Subject: FW: Mazda Garage, 33 Chichester Road

Addition Highway Response (no need for a printed copy)

Subject: RE: Mazda Garage, 33 Chichester Road

BLOCK PLAN  
1:500 @ A3

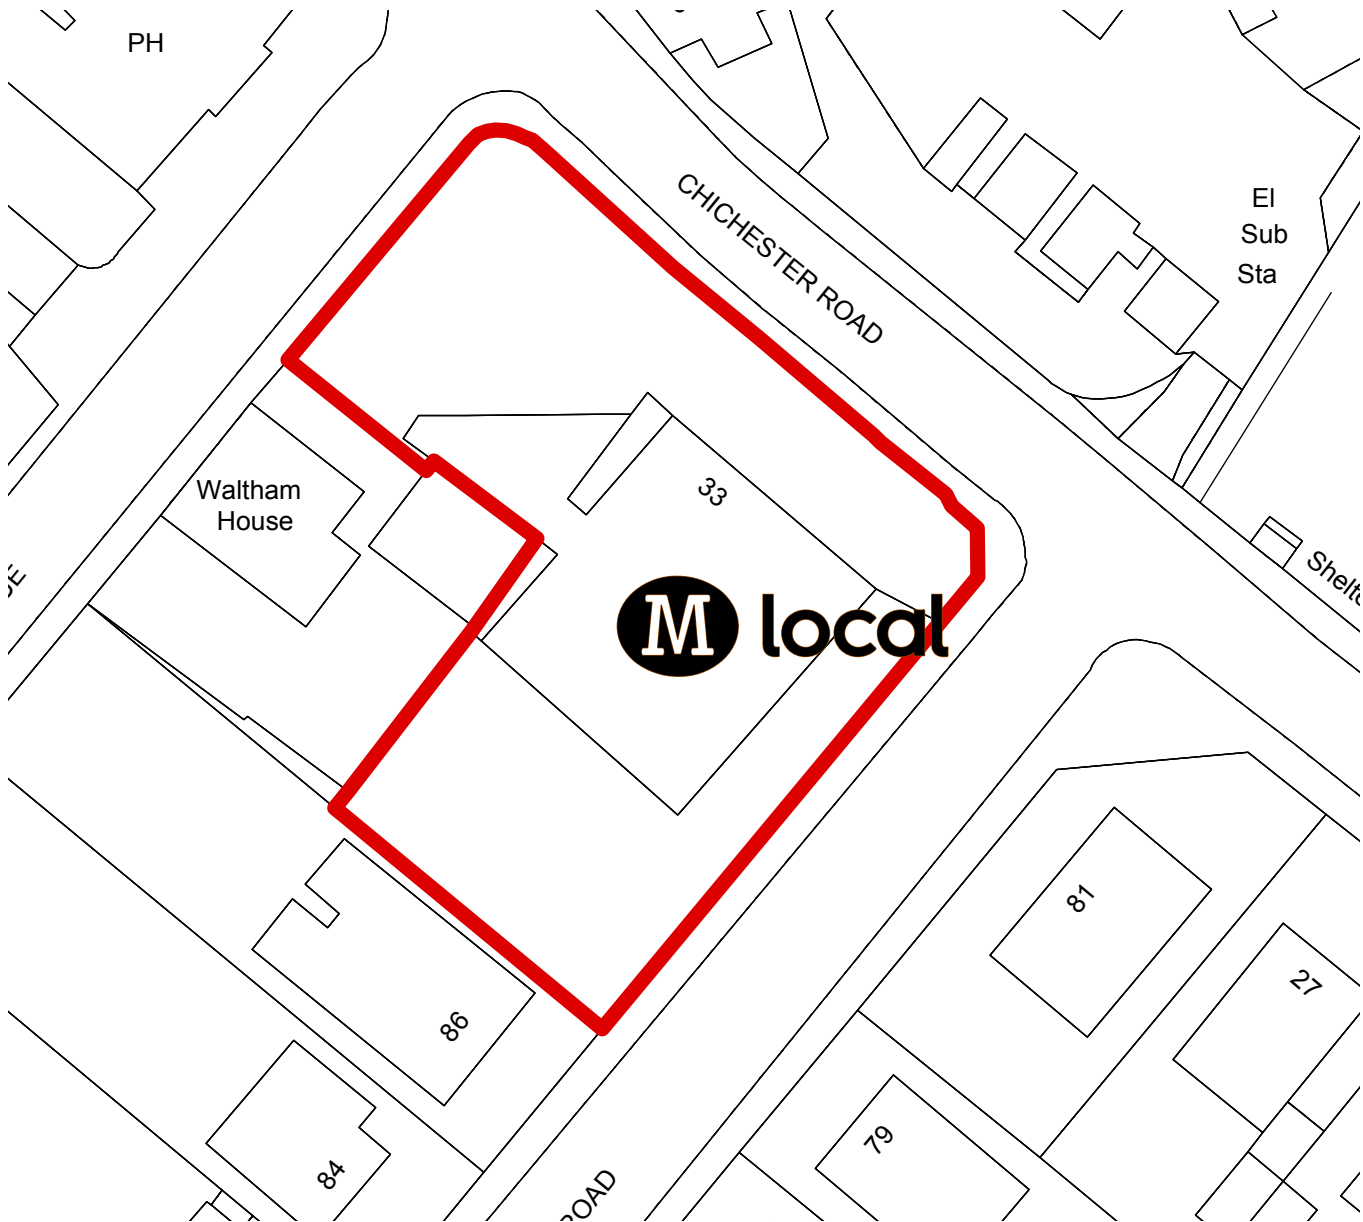
This looks ok. I remember there being dropped crossings in place here, do you know if these are going to be re-done, but this layout is ok.
